Application No: M/47/21/HH
Site Address: 22 Tudor Close Middleton-On-Sea PO22 6DN
Description of works: Removal of existing roof structure, new first floor accommodation and pitched roof above and replacement rear two storey extension and new front porch extension.

Thank you for your internet representation made on 24th April 2021 which has been recorded as support with the comments as follows:

PROPOSED FIRST FLOOR PLAN

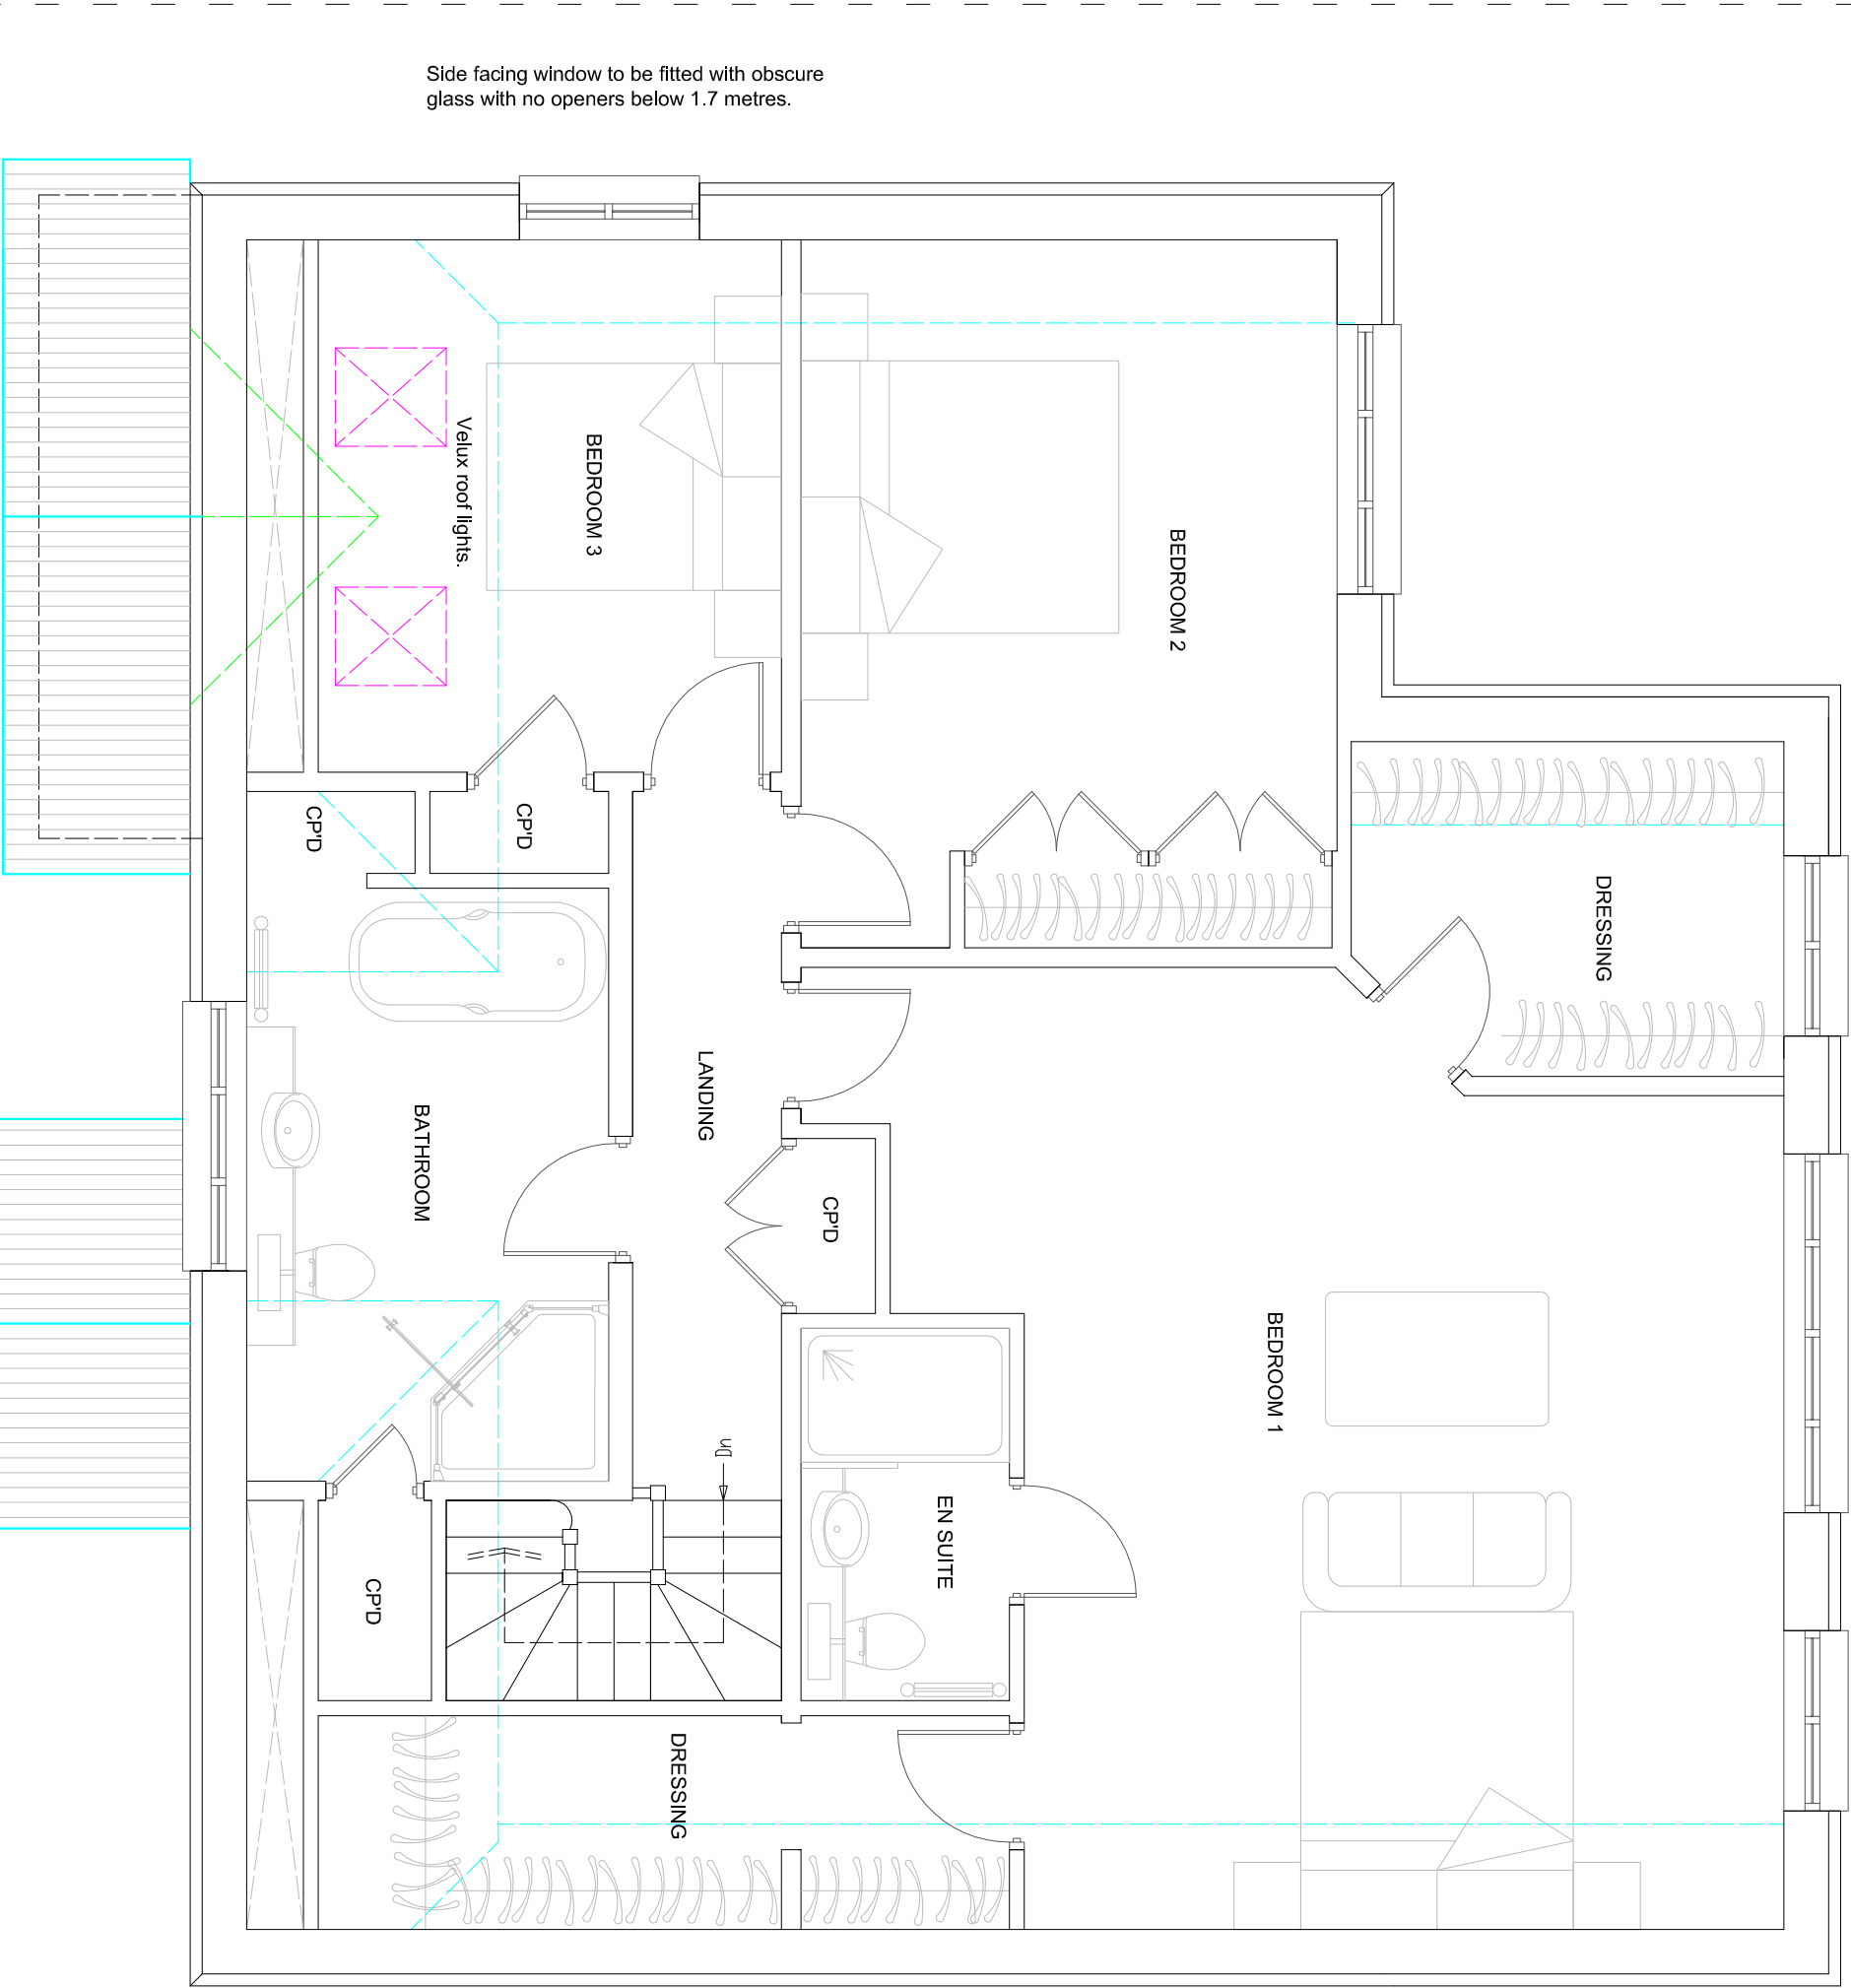
Whilst we are not suggesting this happen, we would ask that consideration be given to the size of the master bedroom main window, and that it be reduced in size.

We would also request that the dressing room window be obscured.

PROPOSED ELEVATIONS

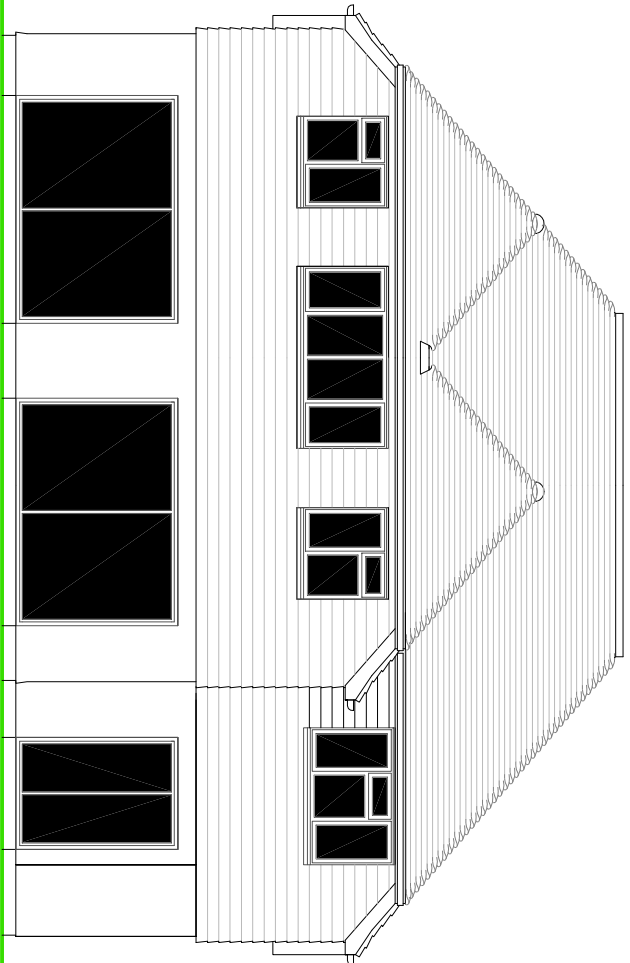
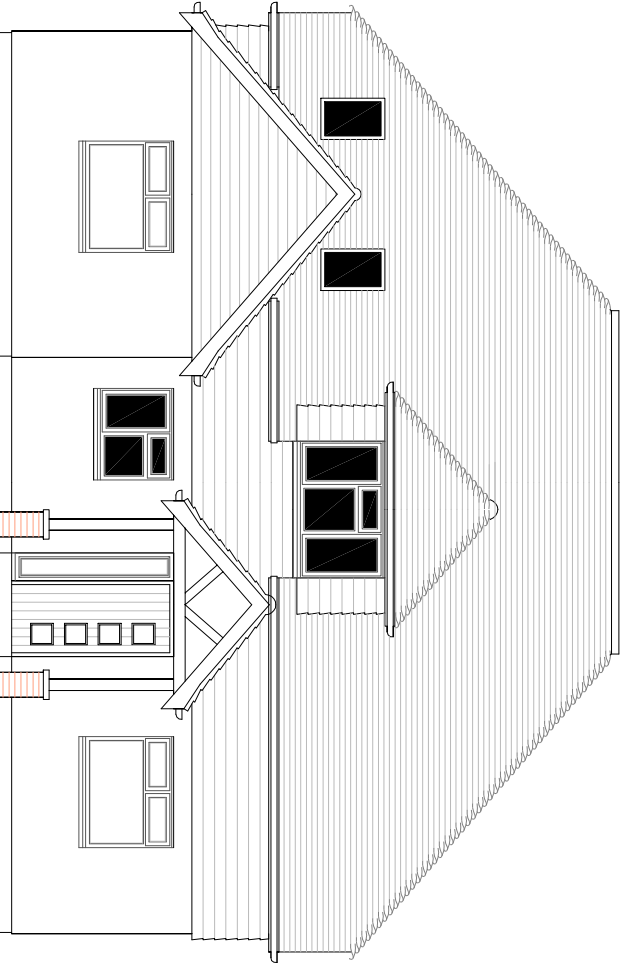
The rear extension first floor windows will over look our garden and look into two bathrooms and a bedroom, we in turn will look directly into a dressing room and two bedrooms. As the rear of the property does not retain the chalet bungalow style that has respectfully been retained in the front of the house it will feel as if we are being over looked by a full flank of windows. It is not in keeping with the existing view of 2 story house to its left.

Can you confirm the height of the top of the rear windows.
